CHENNAI METROPOLITAN DEVELOPMENT AUTHORITY
Thalamuthu Natarajan Building, No.1, Gandhi Irwin Road, Egmore,
Chennai - 600 008

Letter No.B3/3787/2018 , Dated: 24.07.2019

Sub: CMDA – Area Plans Unit - ‘B’ Channel (North) - Planning Permission Application for the construction of Ground Floor +3 Floors Residential Building with 32 dwelling units at S.No.263 part, Block No.81 of Sadayankuppam Village of Manali New Town – Remittance of DC and other charges – DC advice Sent – Reg.

| SIZE | DWG.TITLE. | SITE PLAN |

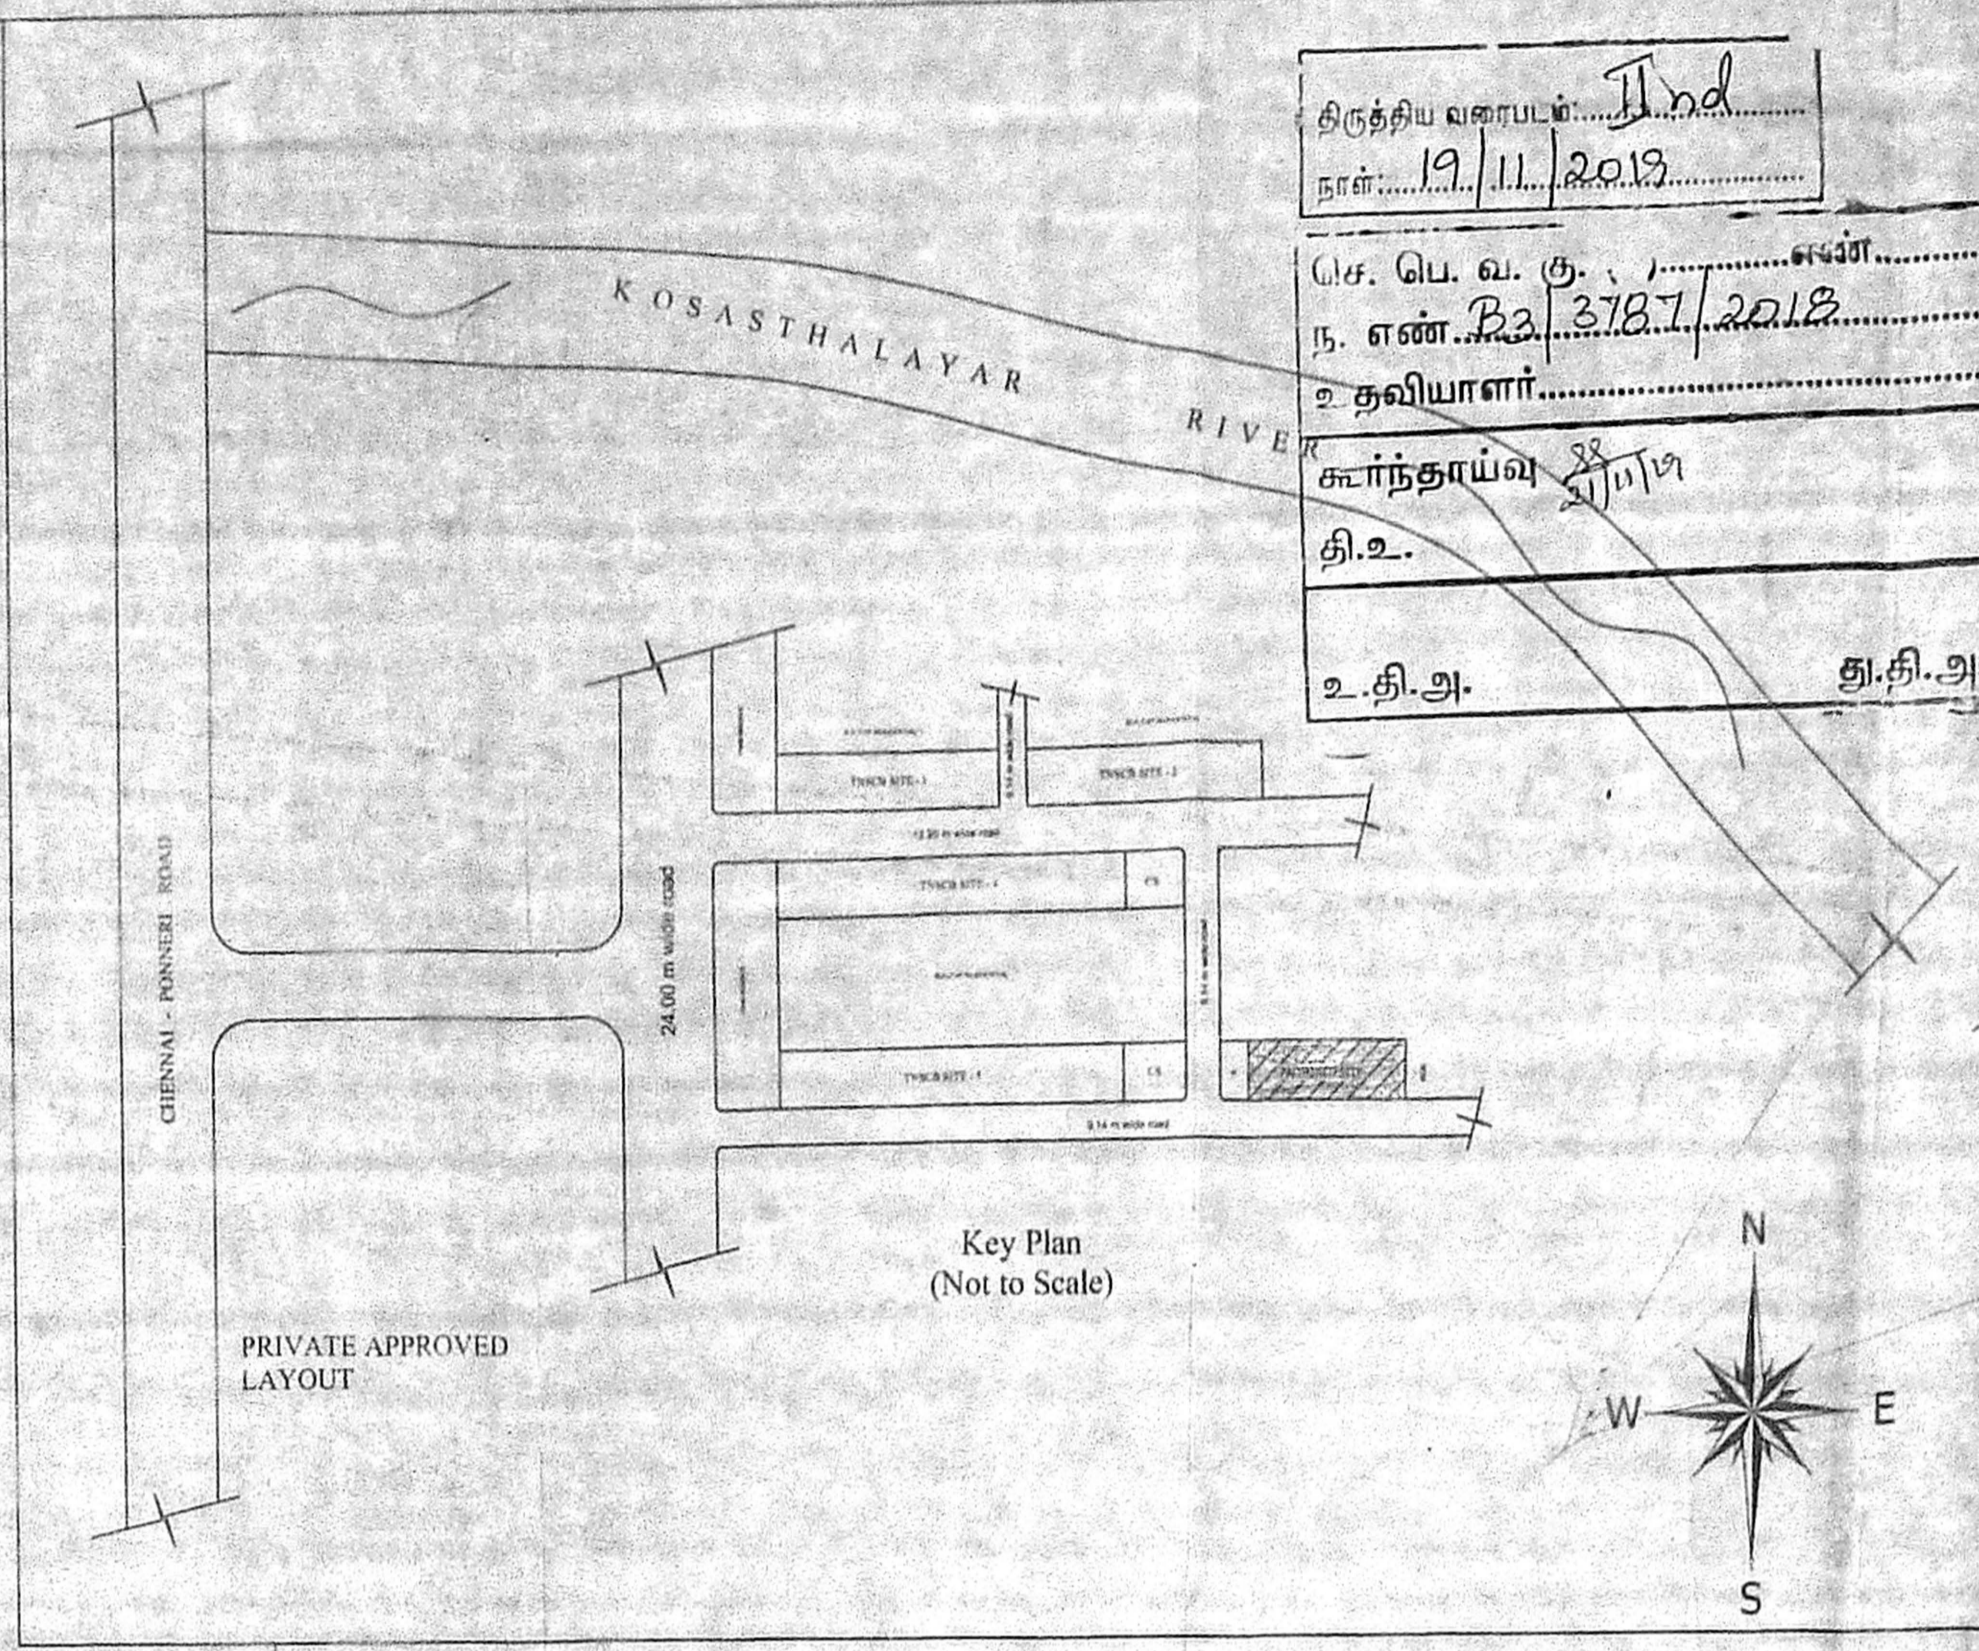
- a) Open Transformer yard to be shown in the plan. ✓
- b) ³⁵53 nos. of Two Wheeler parking to be shown.
- c) Site boundary measurement on eastern side to be shown in the site plan.
- d) Column position to be shown in the floor plan.
- e) Parapet wall height to be shown as 1.00m.
- f) Applicant should not sign in the front page of Form C.
- g) PP1 to be furnished.

- h) Open mid-landing to be shown in the floor plan.
- i) Building breakup measurement and overall measurement to be shown in the eastern side of the floor plan.
- j) Area statements need correction.
- k) Building breakup measurements do not tally with overall measurement.
- l) Form B submitted in the name of TNSCB but signed by DP TNSCB which is not acceptable.
- m) Person who has applied for planning permission sign in Form B, Form C, PP1, PP2 etc.
- n) The same person should not sign to the capacity of applicant and License Surveyor.
- o) Same person should not sign in the applicant, Structural Engineer, License Surveyor, PP1, PP2 and plans.
- p) Site plan drawn in the readable scale.
